KIRKLEES METROPOLITAN COUNCIL INVESTMENT & REGENERATION SERVICE

DELEGATED DECISION TO DETERMINE APPLICATIONS FOR CONSENT, AGREEMENT OR APPROVAL REQUIRED BY CONDITION

Reference No:	2026/44/91639/W
Site Address:	Fartown Village Hall, Ball Royd Road, Fartown, Huddersfield, HD2 1AN
Description:	Discharge of condition 3 (vehicular parking/management) on previous permission 2025/91019 for change of use from village hall F2(b) to mosque F1(f)
Recommending Officer:	Emma Thompson

Discharge of condition 3 (vehicular parking/management) on previous permission 2025/91019 for change of use from village hall F2(b) to mosque F1(f)

DRAWING TITLE  
PROPOSED CAR PARK STACKING

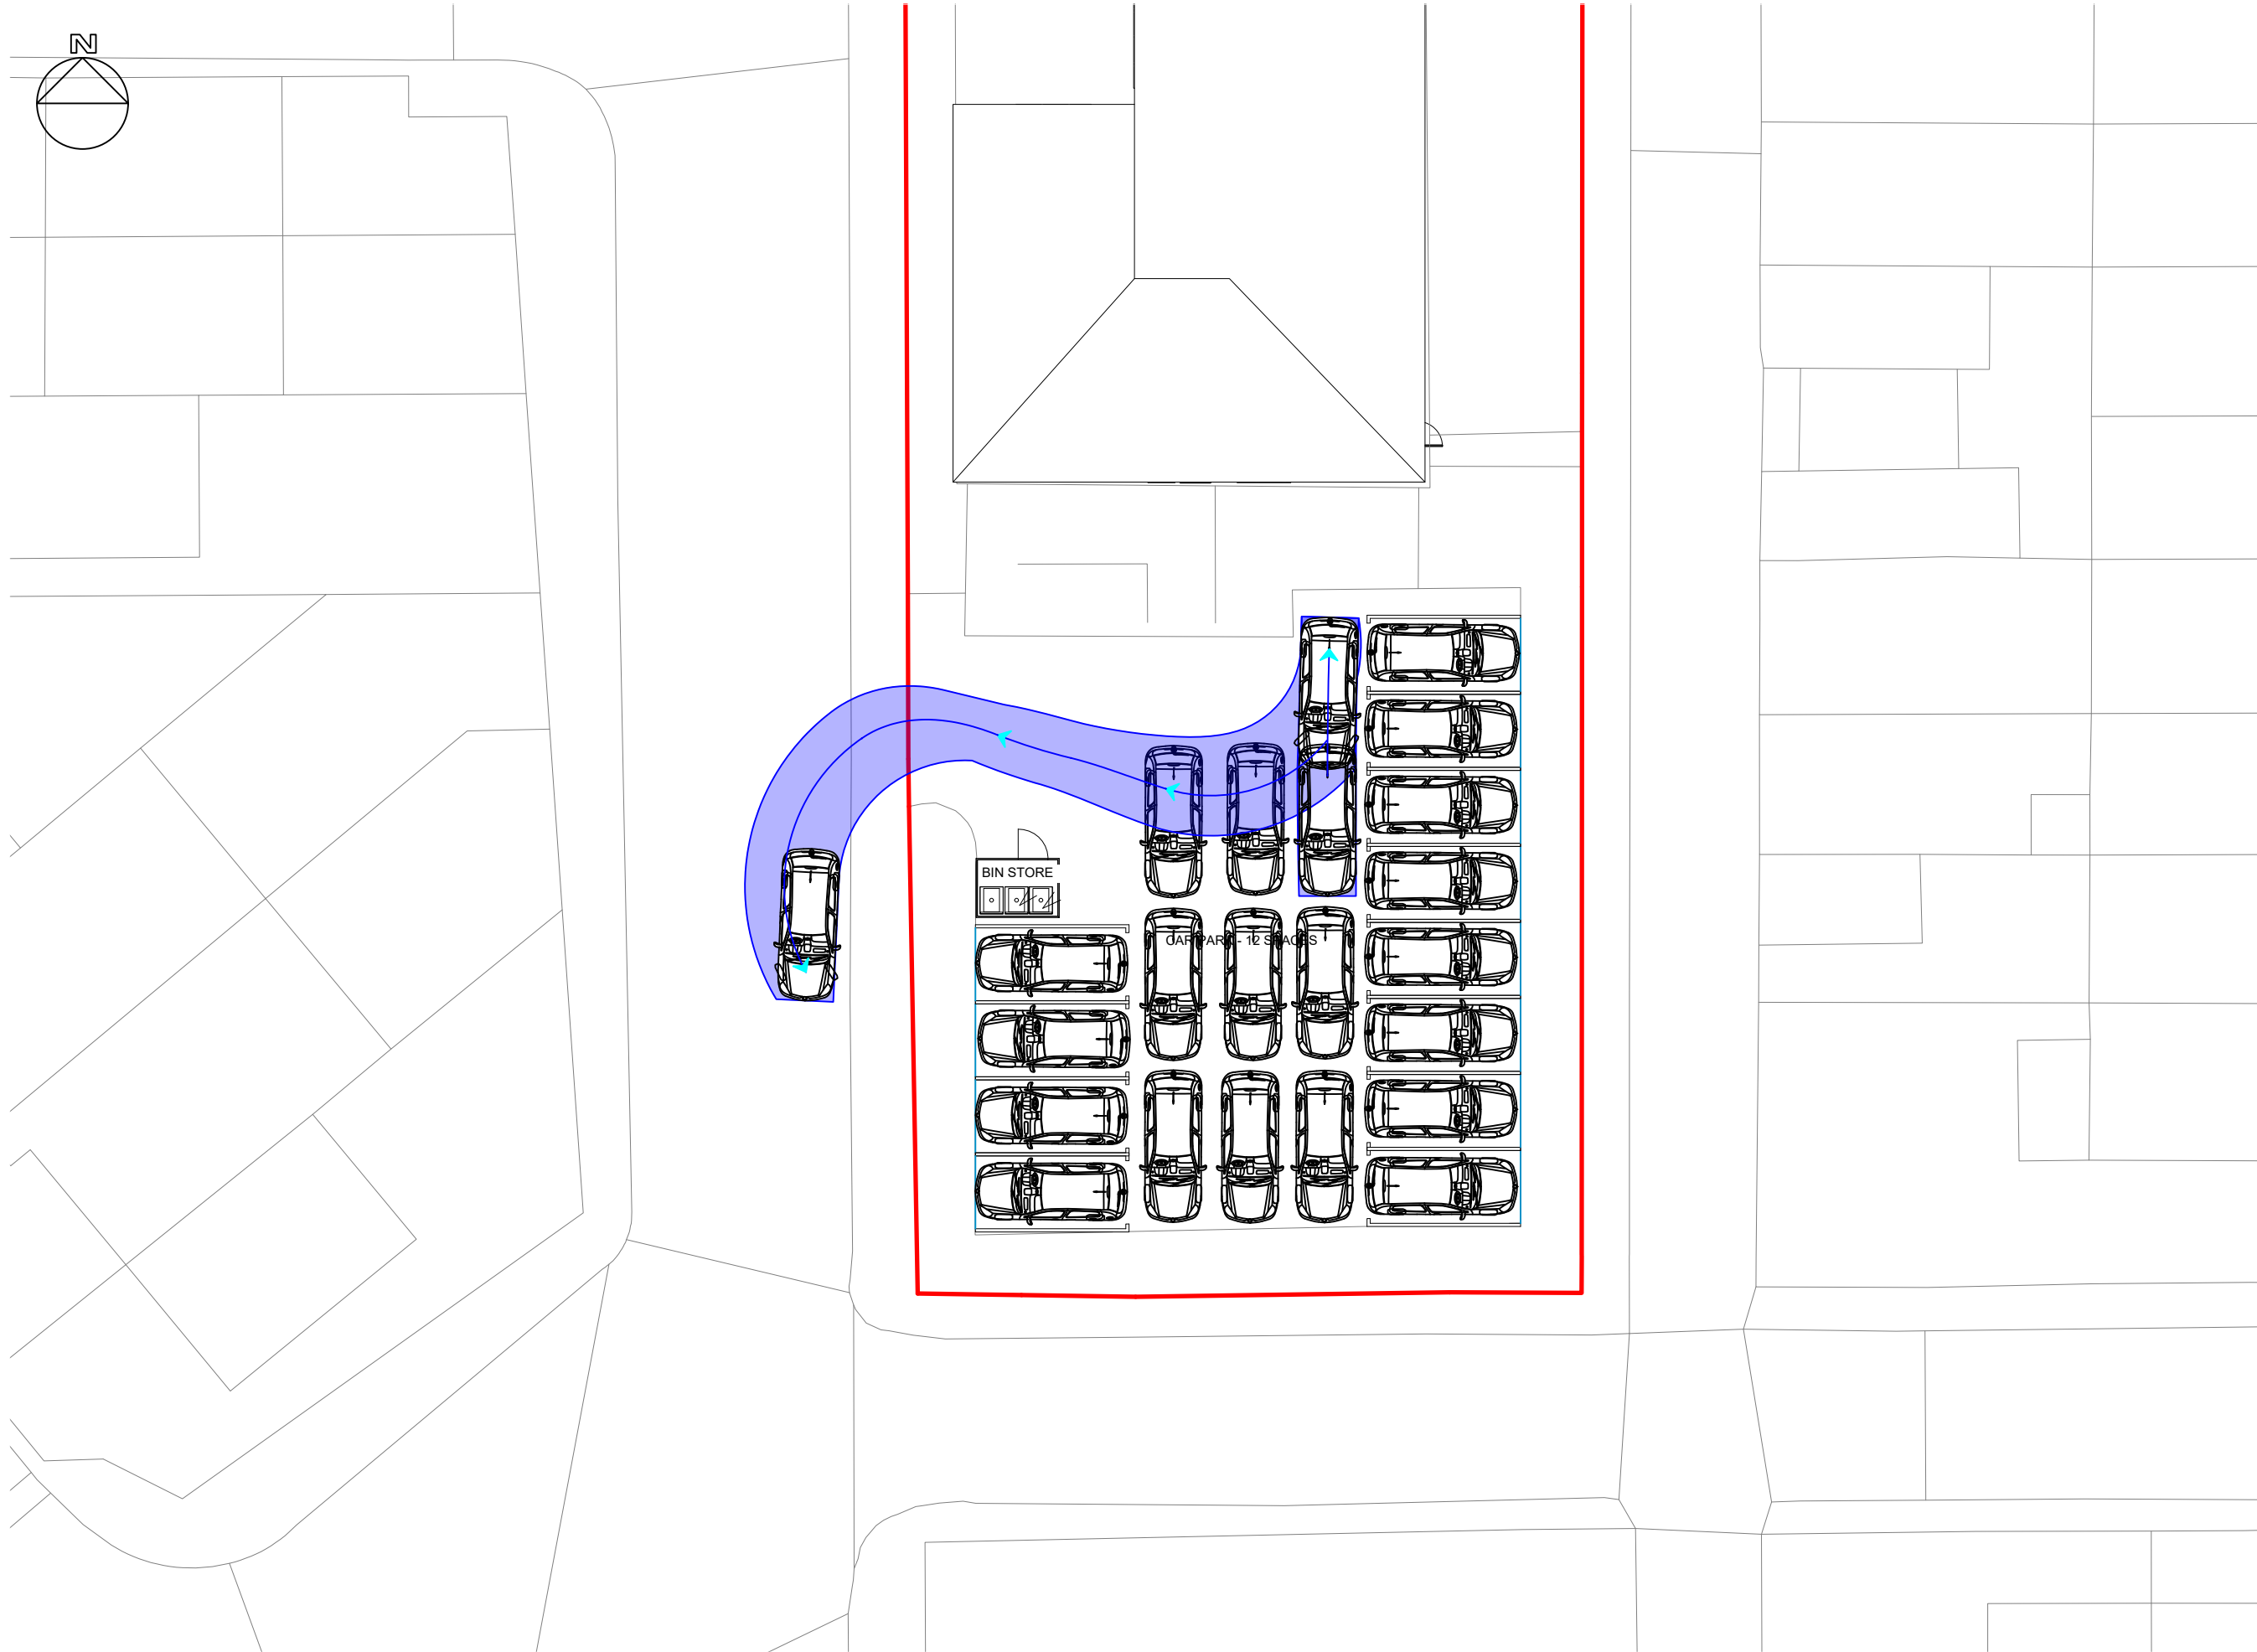
Drawing No 0001 Proposed Car Park Stacking presented in Appendix B of the Vehicular Parking & Management Plan shows a maximum of 21 cars can be stacked in the car park and this would significantly reduce the on-street parking demand around the site, whilst KC Highways DM consider the proposed parking demand of 11 to be relatively low, the general methodology of the trip generation is accepted and the stacking arrangements shown in Appendix B to satisfy part i. of Condition 3 are sufficient for discharging this part of the condition..

The information and plans contained in Vehicular Parking & Management Plan dated June 2026 Project number 2590 from Paragon Highways are acceptable for discharging Condition 3. The development shall be operated in accordance with the approved parking and management plan in perpetuity.
